**Re: Objection to MP08\_0244 MOD 1 Modification Request for Mixed Used Development at 23-37 Lindfield Avenue and 11 Havilah Lane, Lindfield**

As a resident of Lindfield, I/we wish to lodge an objection against the proposed Modification of the subject development based on the following grounds:

1 HAVILAH LA ELEVATION
2001 SCALE1 : 250

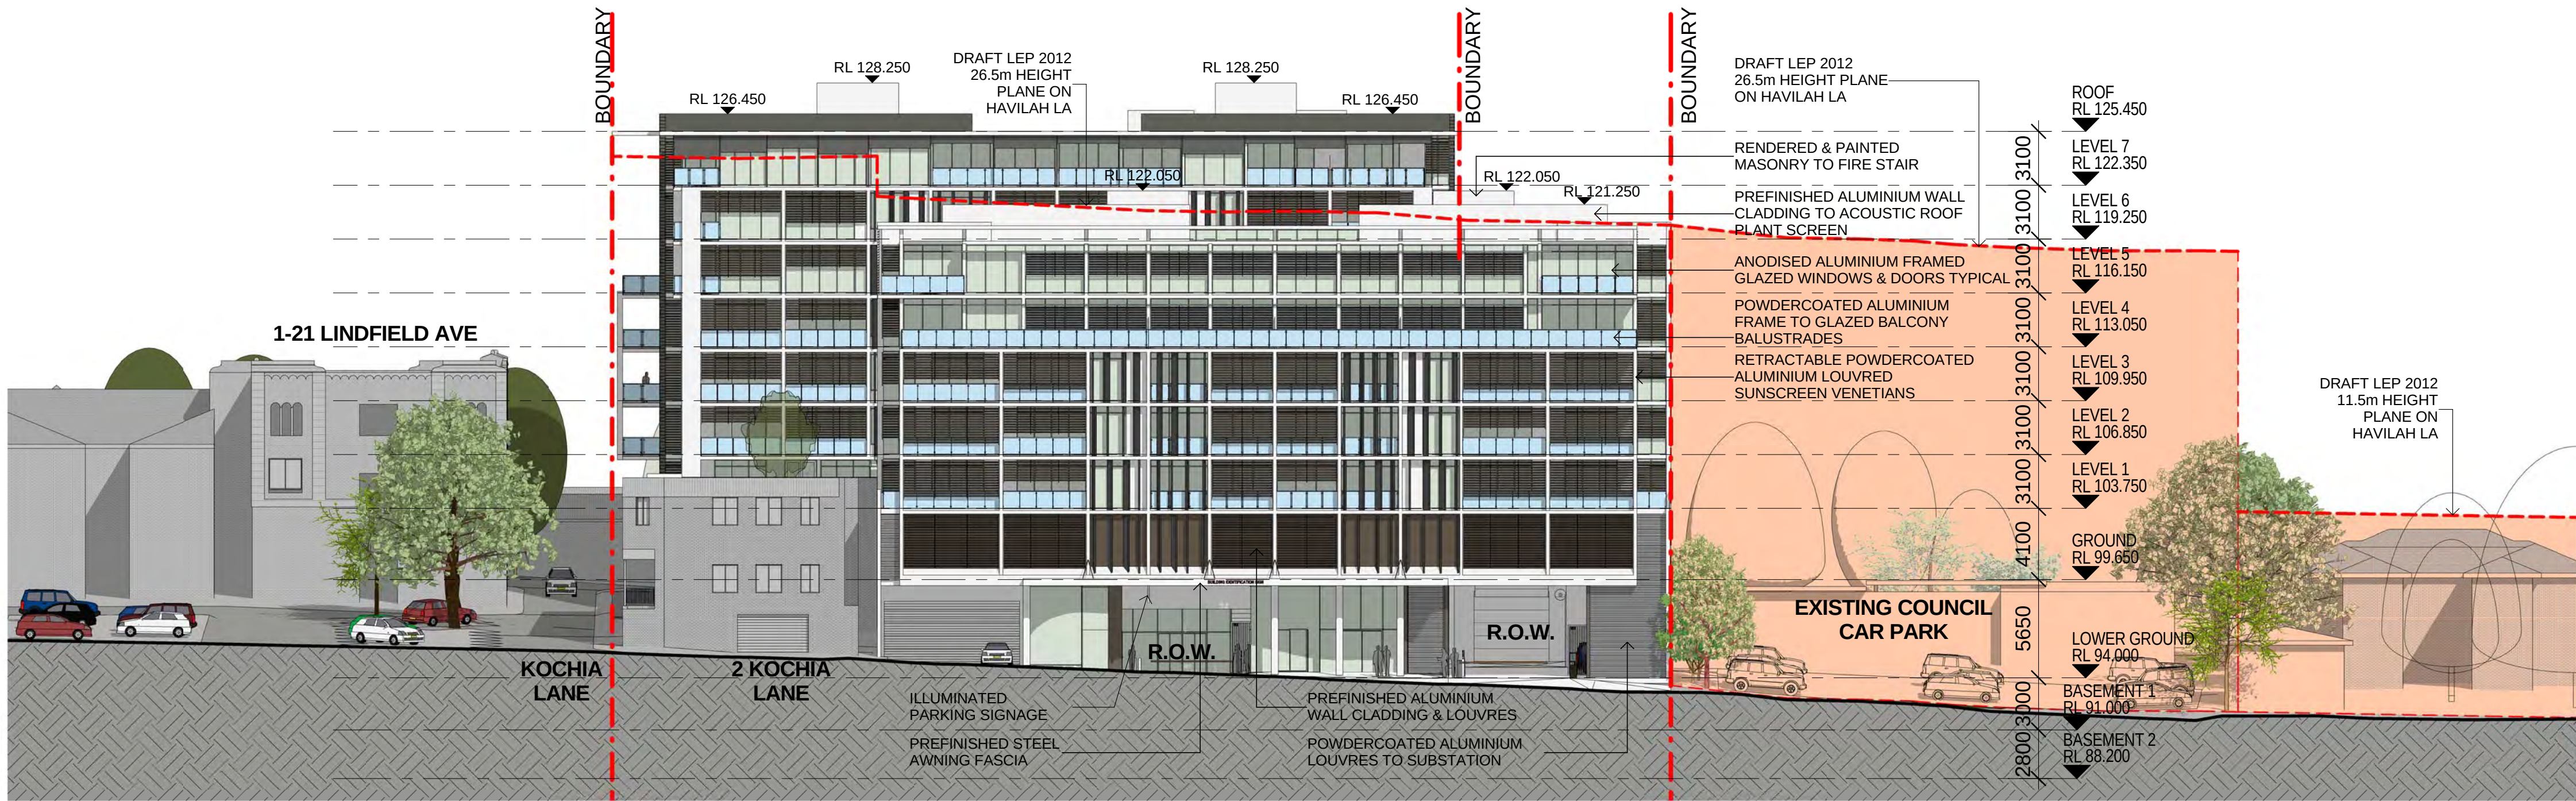
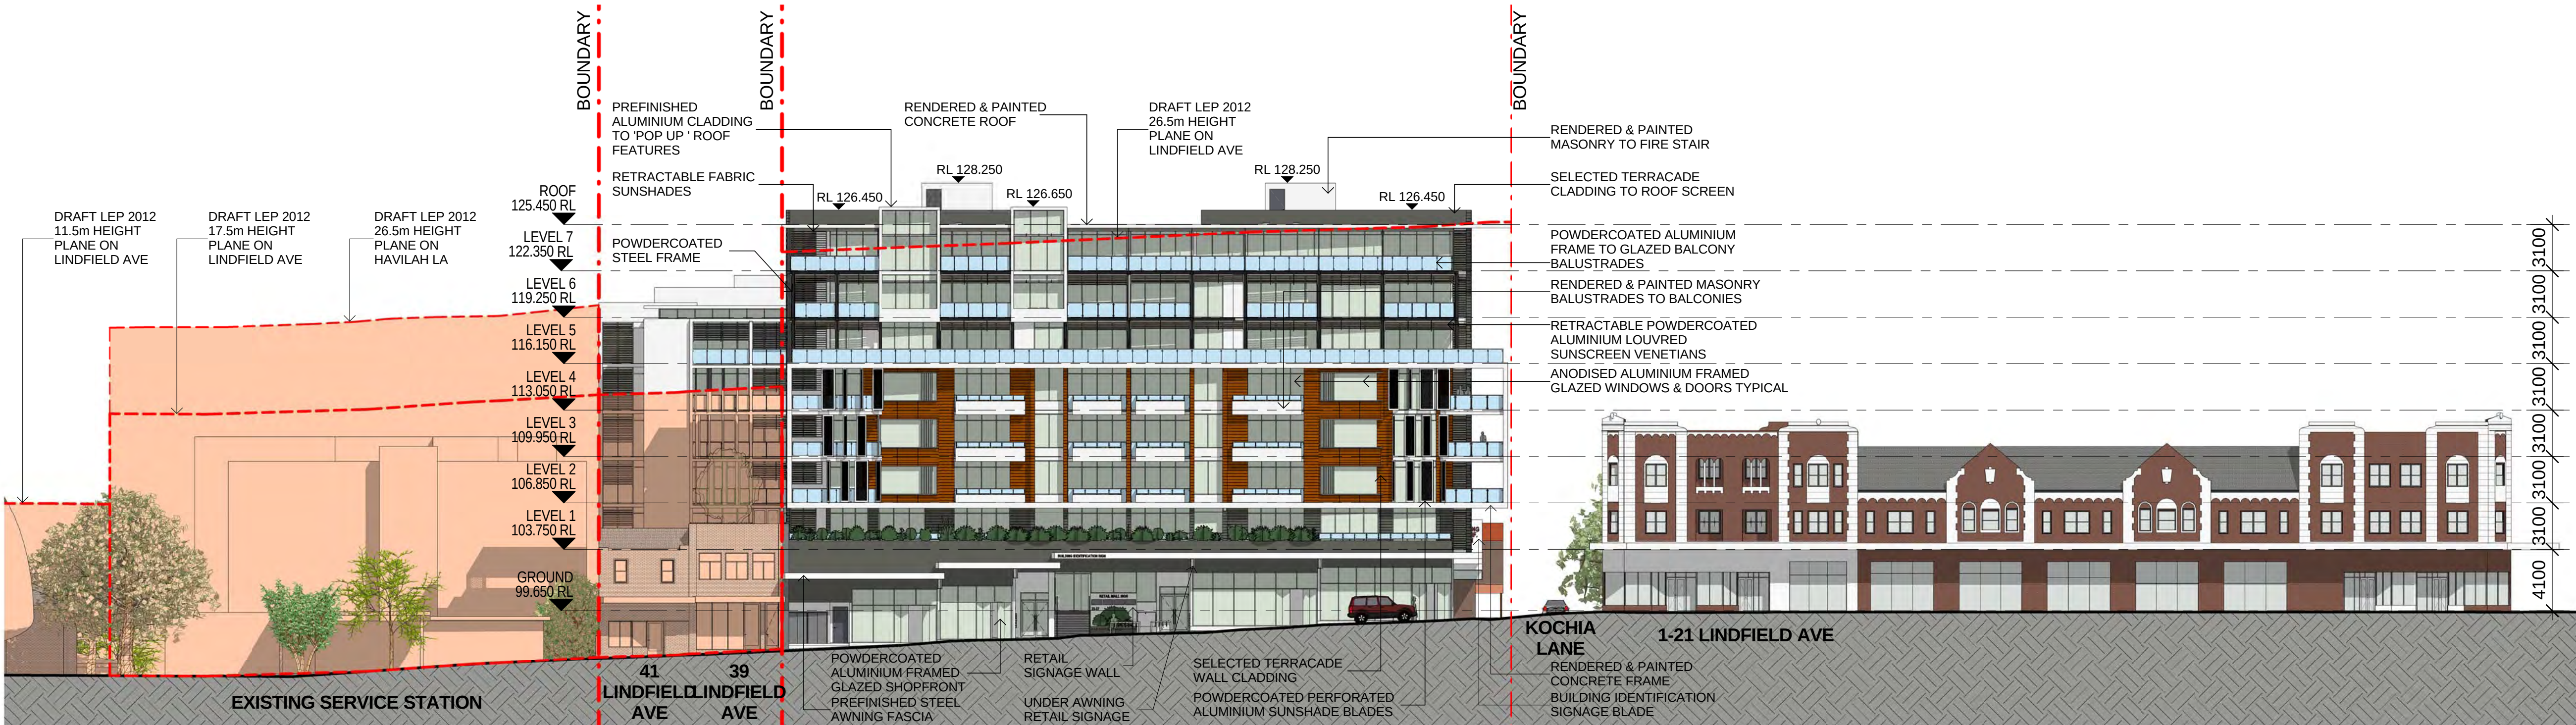
- The increase of an additional storey to both buildings: 8 storeys on Lindfield Avenue and 7 storeys on Havilah Lane creates excessive height and bulk and is out of character with the surrounding buildings, including the heritage listed adjacent building on Lindfield Avenue

- The additional storey (combined with less set back than the approved design) on Havilah Lane now creates privacy concerns for over 40 apartments in the adjacent 8 Havilah Lane, 8 Kochia Lane and 2-8 Milray Street residences
